# **City of Albuquerque**

**RE: ZANIOS FOODS (K10-D21A) GRADING PLAN FOR BUILDING PERMIT  
APPROVAL. ENGINEER'S STAMP DATED 1-22-96.**

GRADING PLAN

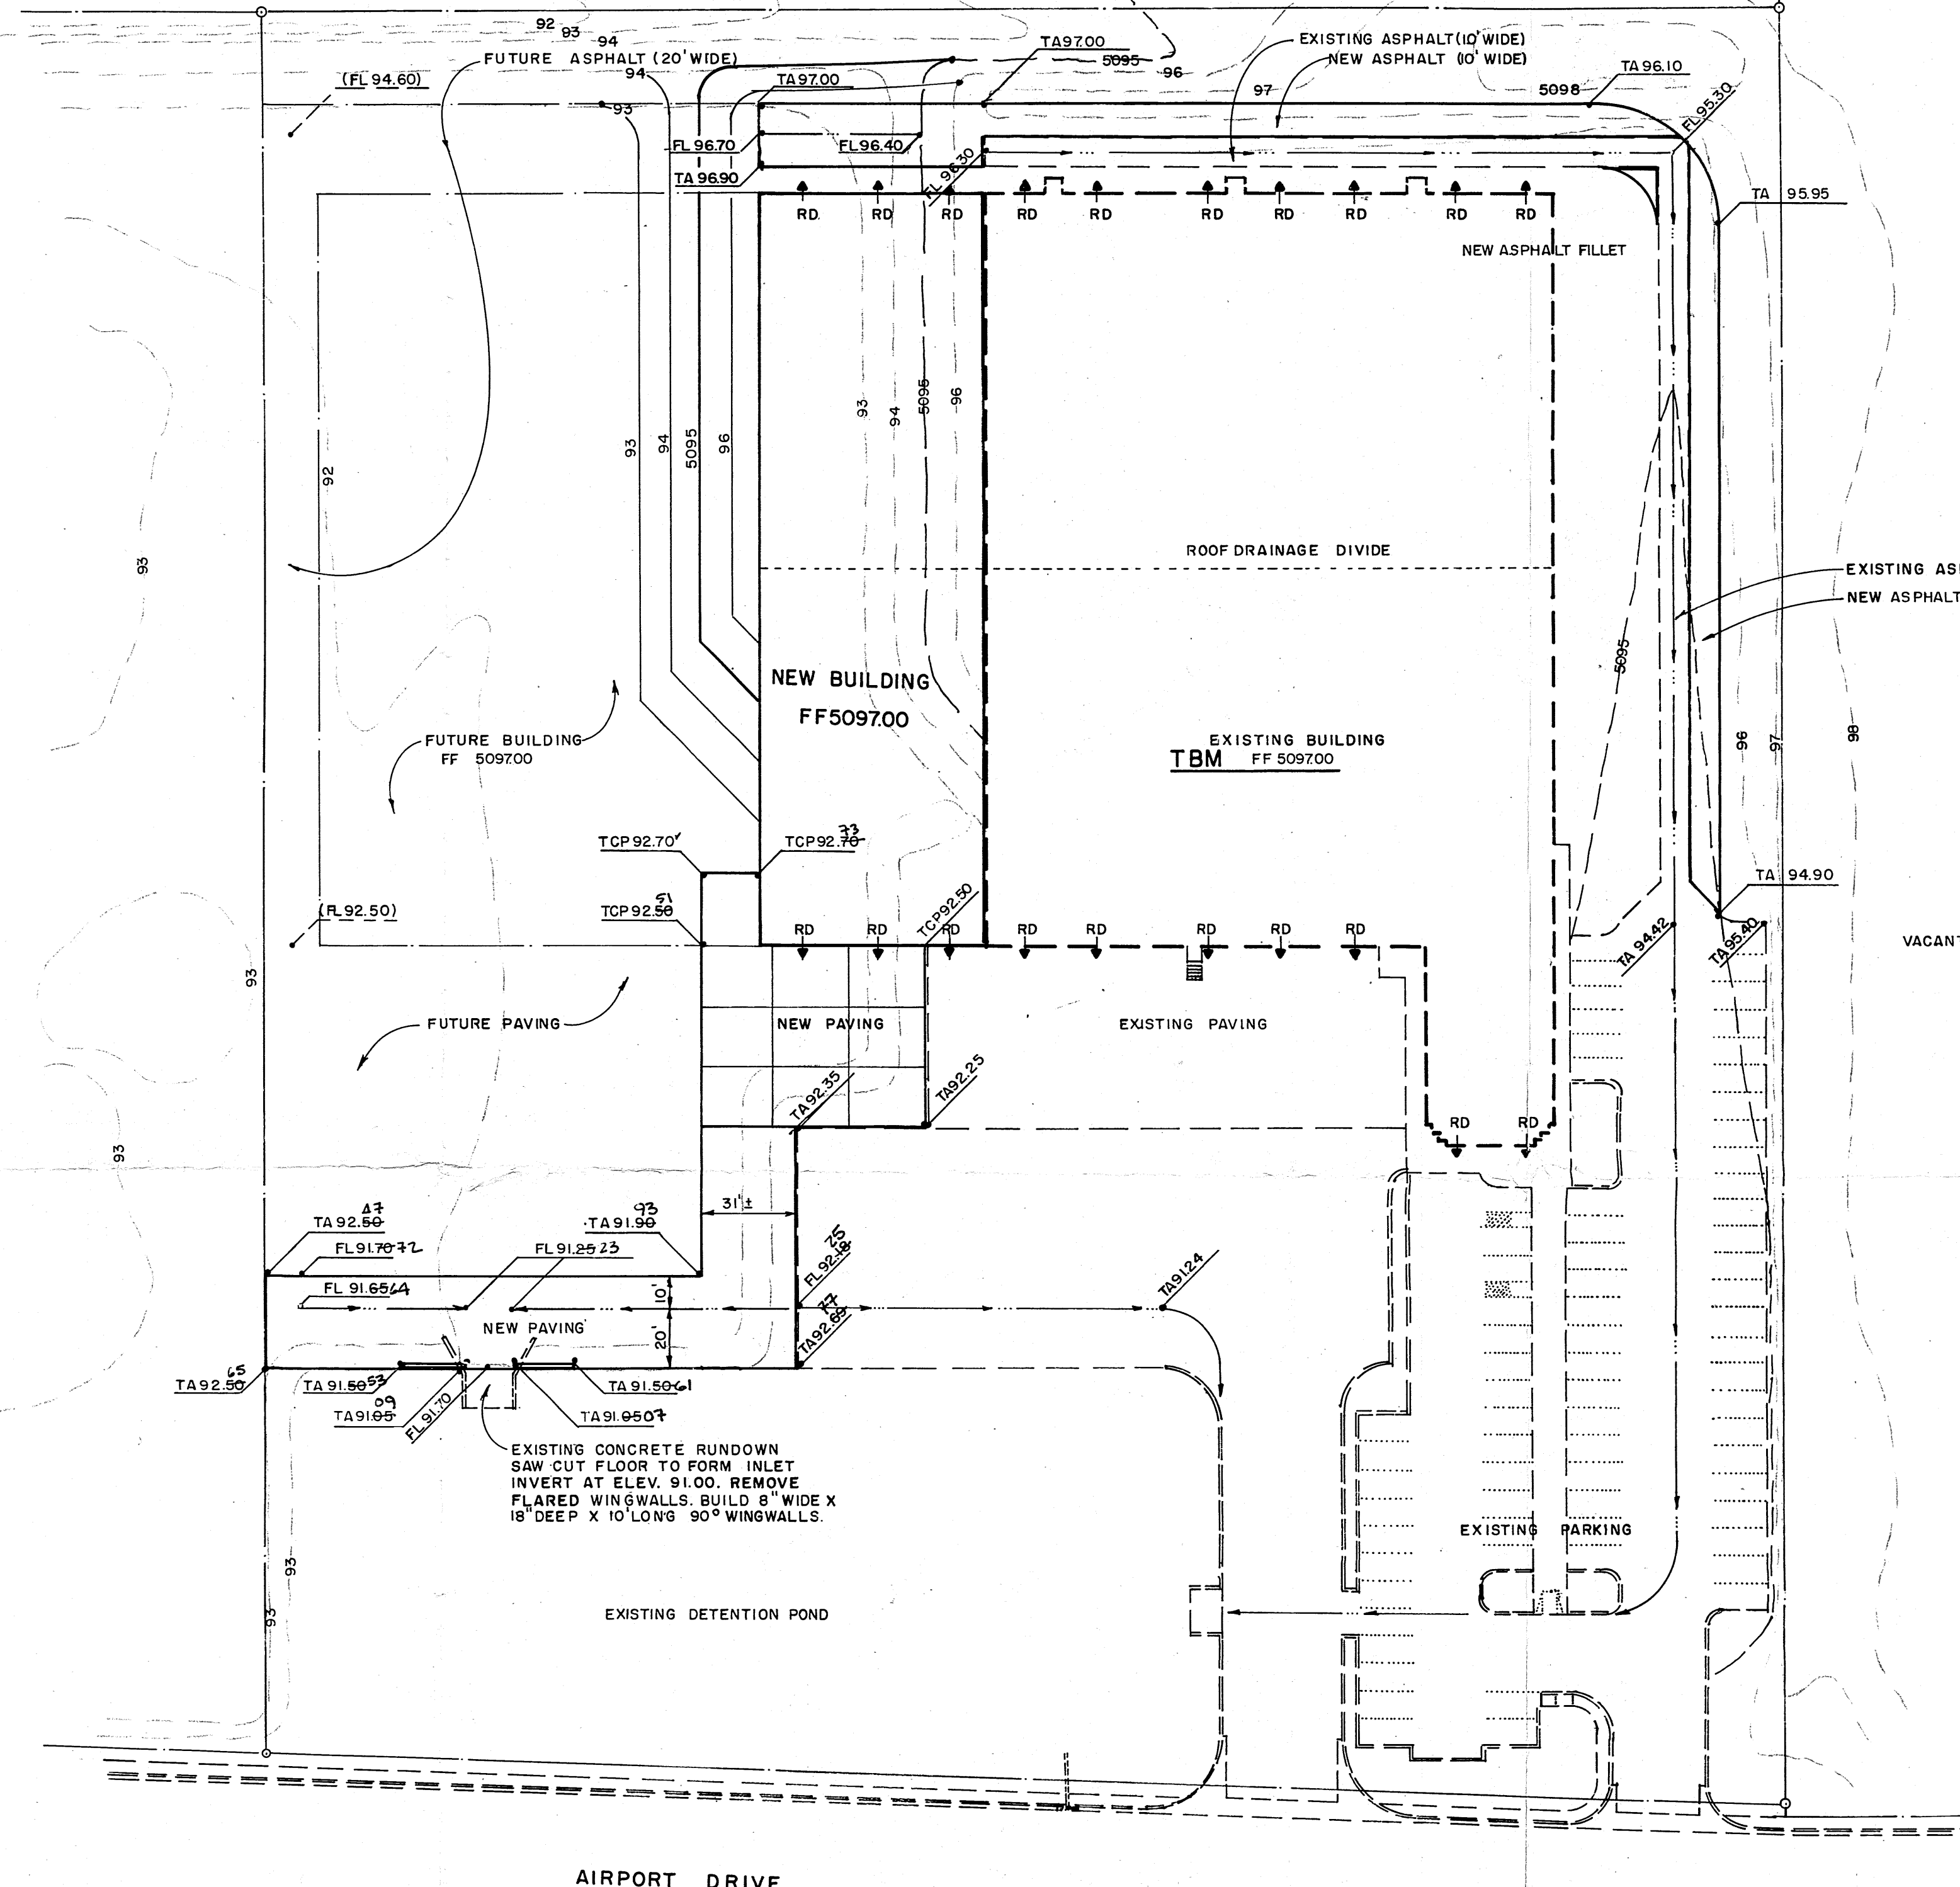
1. What is being built? I assume it is the structure  
titled "New Building." A short narrative, explaining  
the intent of the plan would be very helpful.
2. What effect does the building(s) have on the amount of  
runoff generated?
3. Please provide drainage calculations.
4. Show, on the plan sheet, an on-site, temporary bench  
mark
